CITY OF ALBUQUERQUE

March 10, 2025

**Re: Mister Car Wash
1020 Juan Tabo NE
Conceptual Traffic Circulation Layout for DFT Approval
Engineer's Stamp 3-4-25 (J22D074)**

<p>RONALD R. BOHANNAN P.E. #7868</p>	MISTER CAR WASH ALBUQUERQUE, NM	DRAWN BY pm
	TRAFFIC CIRCULATION PLAN	DATE 10-9-25
	<p>TIERRA WEST, LLC 5571 MIDWAY PARK PL. NE ALBUQUERQUE, NEW MEXICO 87109 (505) 858-3100 www.tierrawestllc.com</p>	DRAWING
		SHEET # 4 JOB # 2025017

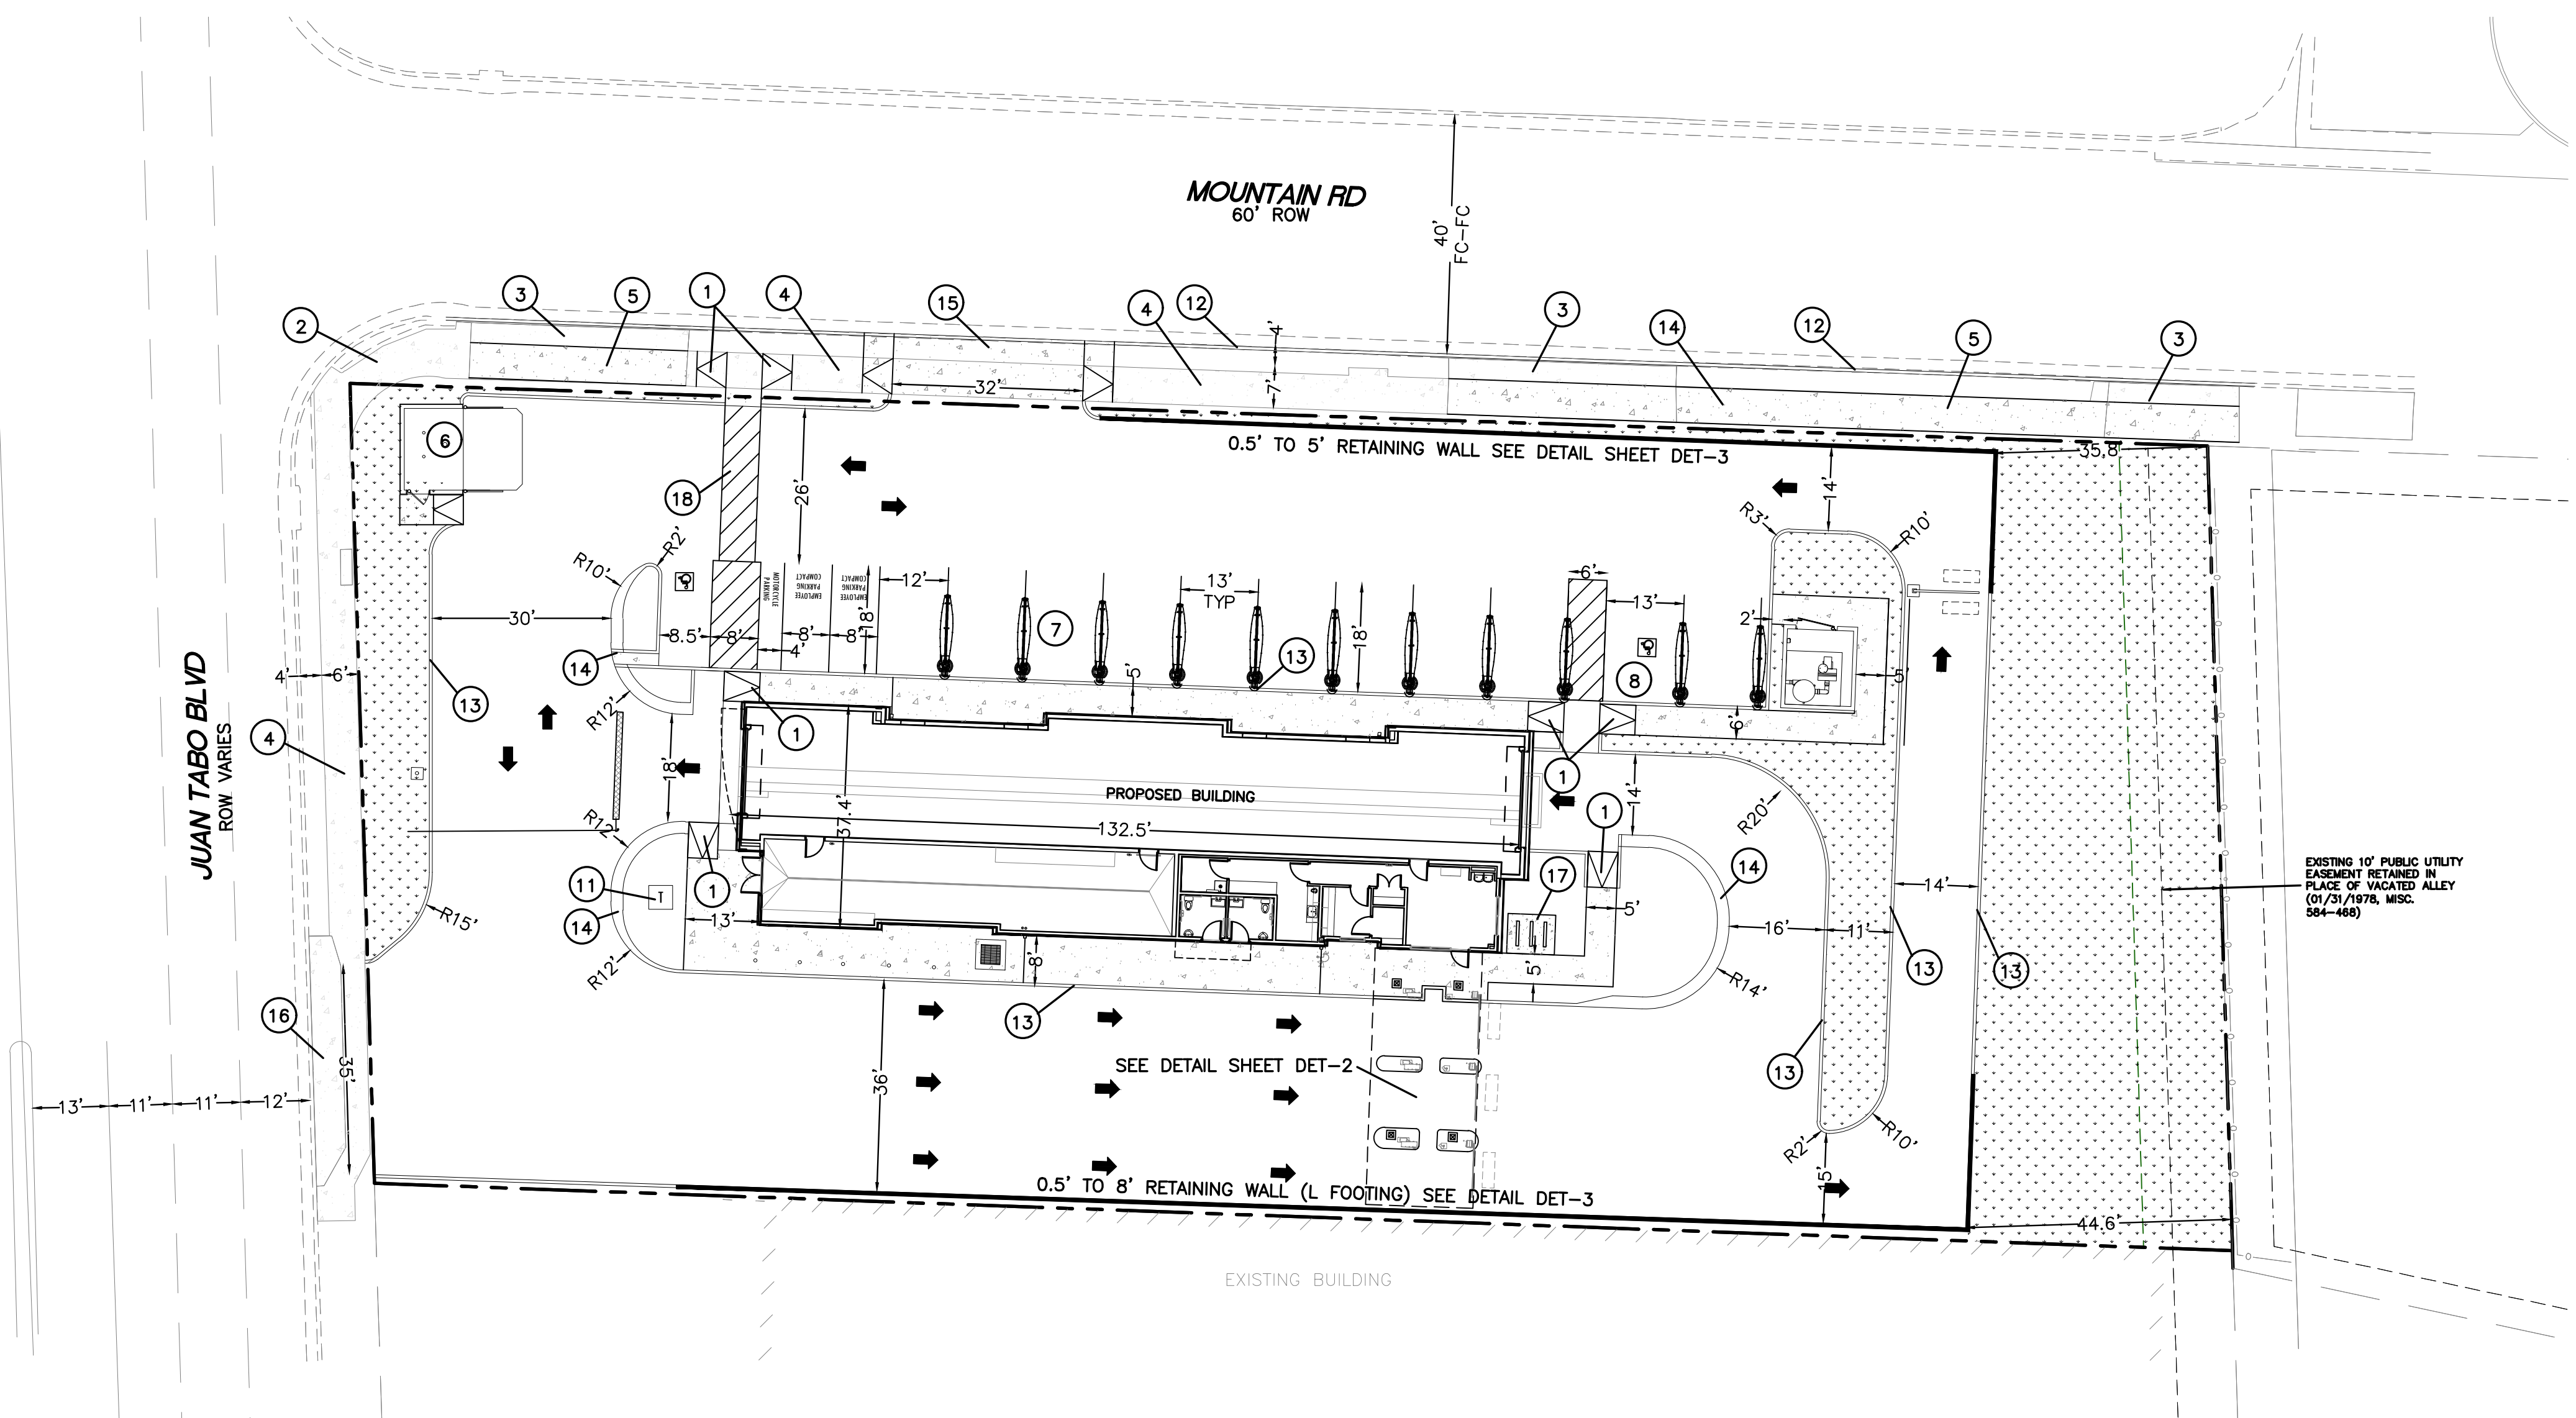
- 1-The first existing entrance on Mountain should be blocked.**
- 2-The far east 14 ft existing entrance on Mountain may be widened to 26 ft if needed.**
- 3-The Car Wash Use stalls may be counted as parking space. And**
- 4-One ADA Van, one Motorcycle, and two Bike Racks should be provided.**
